Colston Budd Hunt & Kafes Pty Ltd

8 December, 2009

RE: PROPOSED COMMERCIAL DEVELOPMENT, 100 MOUNT STREET, NORTH SYDNEY

1. As requested, we are writing in response to matters raised by the Department of Planning in relation to the above development. We have previously prepared a report⁽¹⁾ which was submitted with the Part 3A application.
2. In a letter dated 15 October 2009, a number of traffic and parking matters have been raised. These matters, and our responses, are set out below.

**LEVEL 3 - BASEMENT 3**

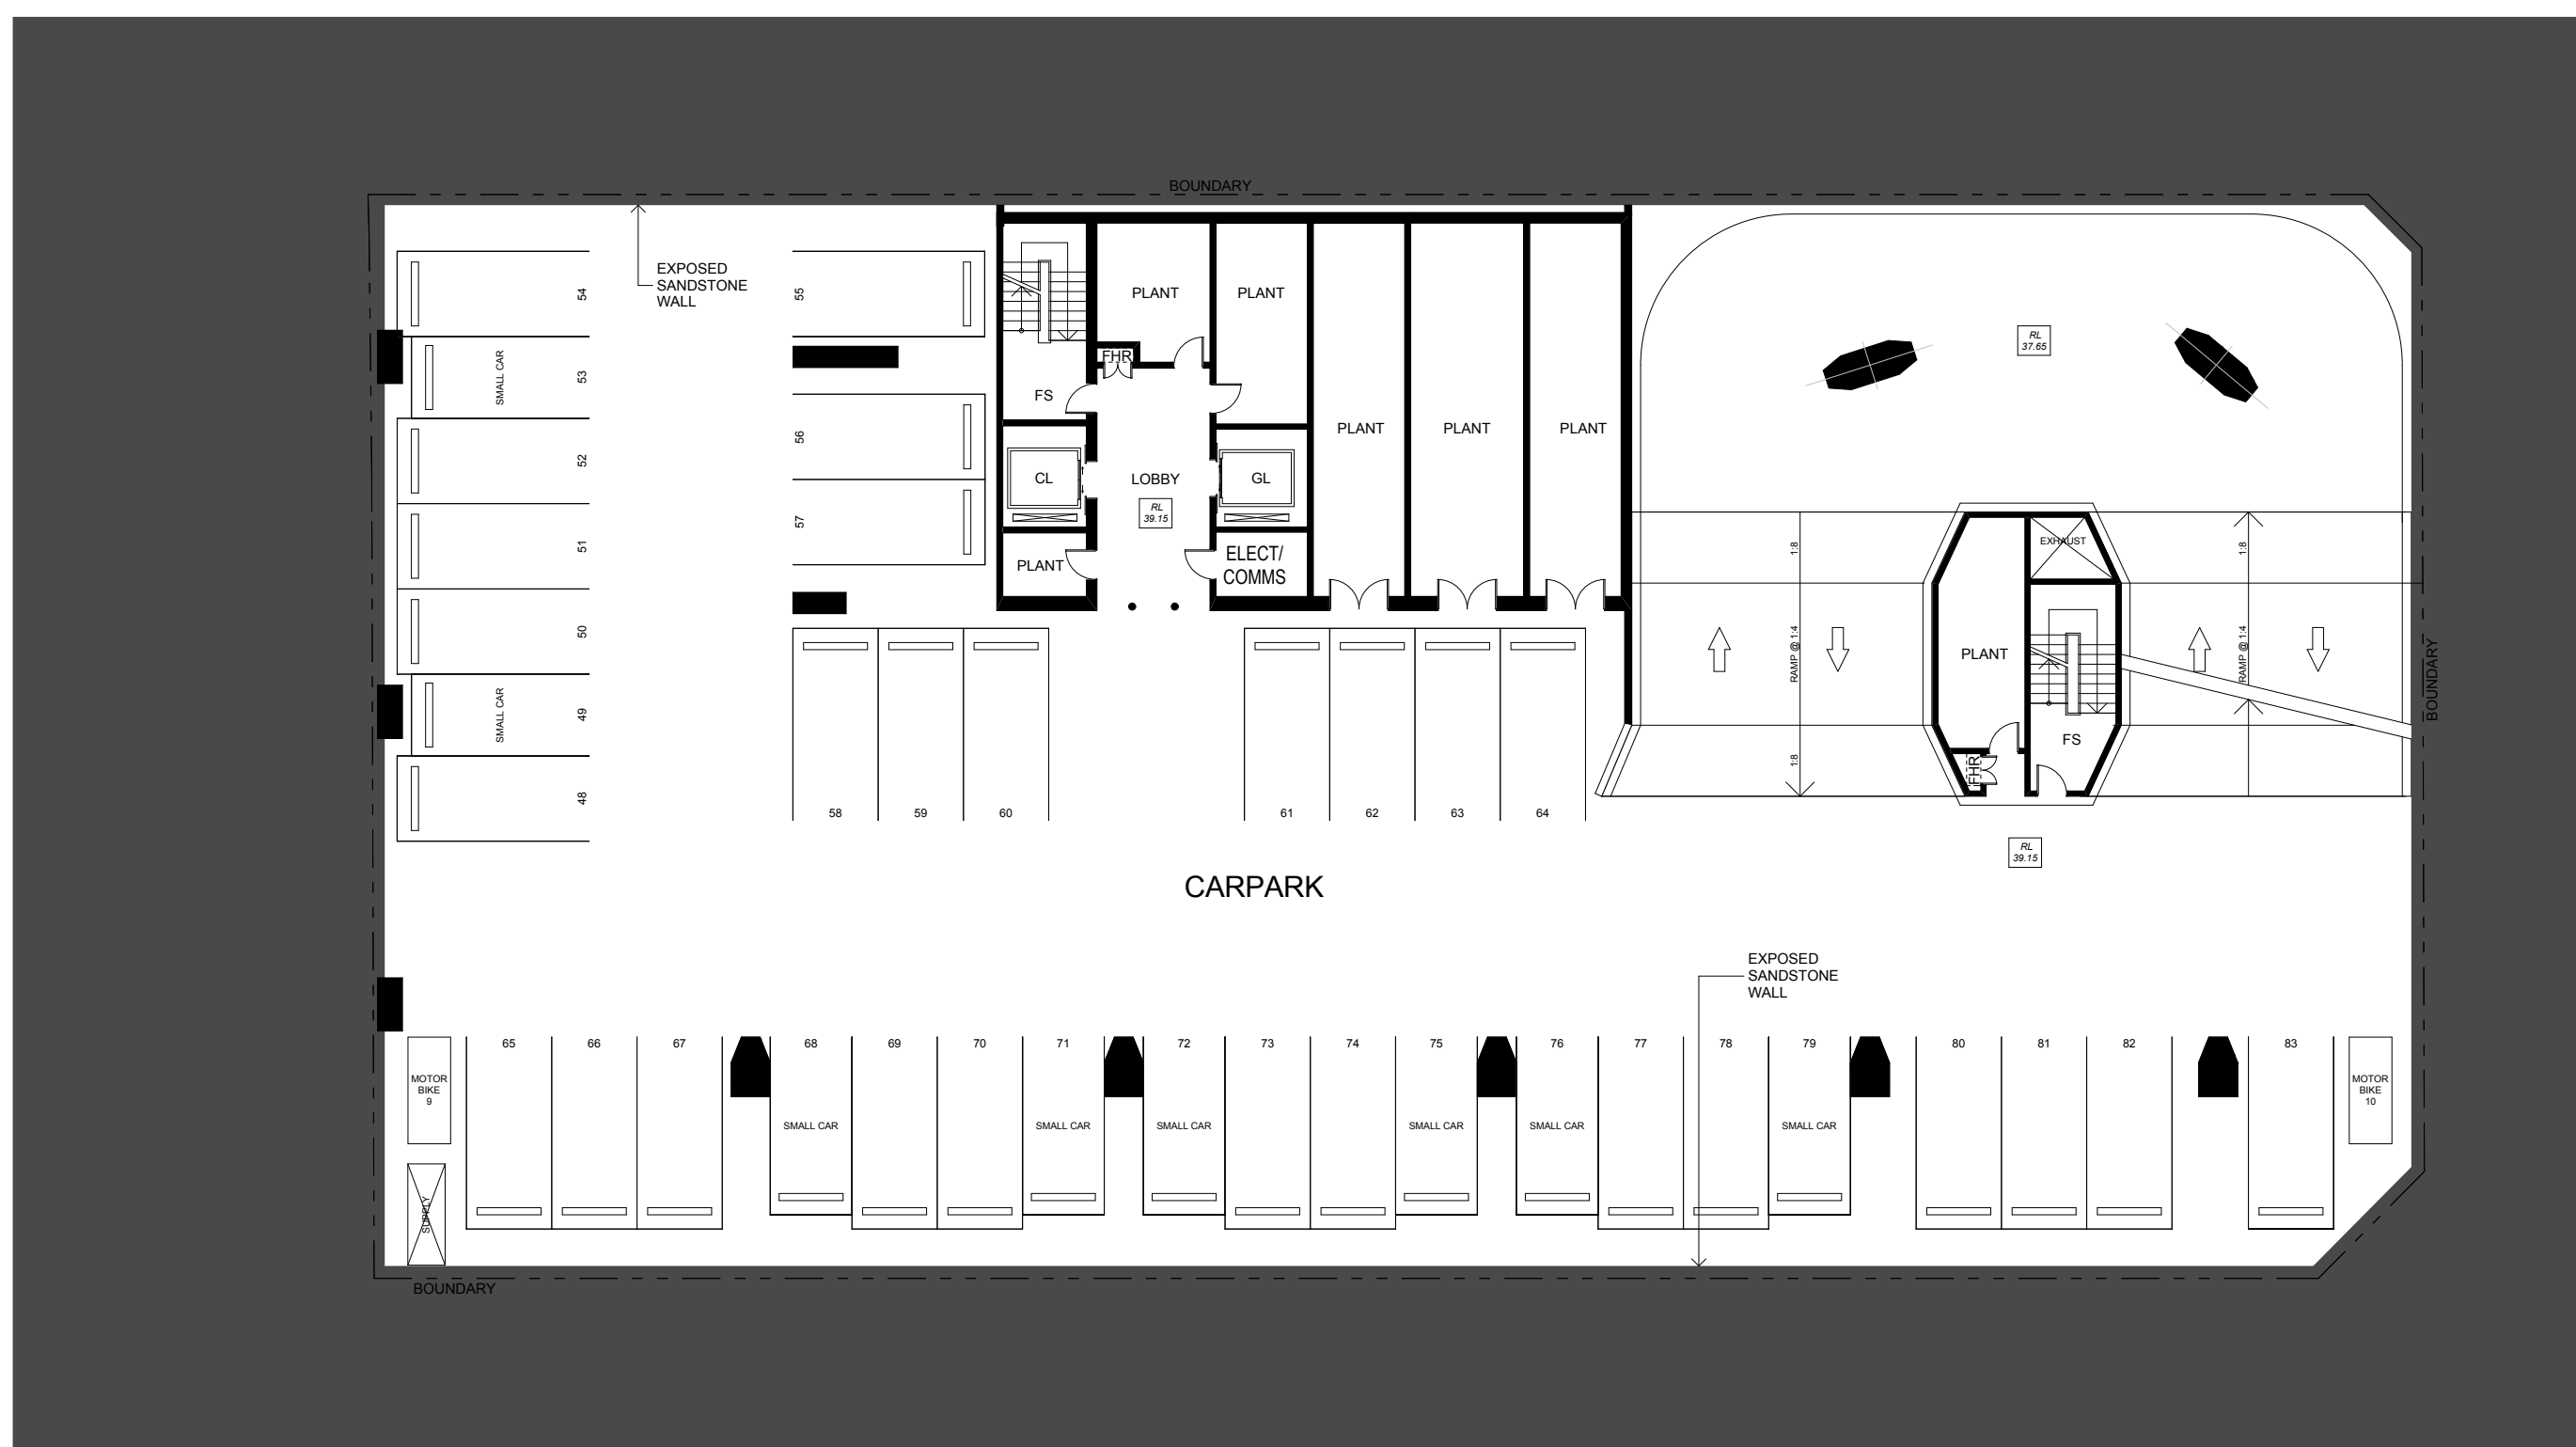
- ***In the event that additional trucks arrive when the loading dock is full what measures are proposed to minimise congestion and impacts on the public domain; and***

- ***A swept path analysis is required to demonstrate that large truck vehicles would be able to enter/exist the subject site and local road network.***

- 7. As noted in our previous report submitted with the Part 3A application, the proposed loading dock will cater for two 8.8 metre medium rigid trucks, plus spaces for vans and courier sized vehicles. The loading dock will be managed and controlled by the loading dock manager.

- 8. Since the preparation of that report, revised plans have been prepared by the architect. The revised plans include the two medium rigid truck bays, as previously, as well as seven spaces for vans and courier sized vehicles.

- 9. There is additional space available, adjacent to the two medium rigid truck bays, for a third truck to use in the event that the other two bays are occupied.

- 10. Swept paths are attached as Figures 1 to 5 showing 8.8 metre medium rigid trucks and 6.4 metre small rigid trucks entering the site from Spring Street and Little Spring Street, manoeuvring into the loading bays and exiting in a forward direction.
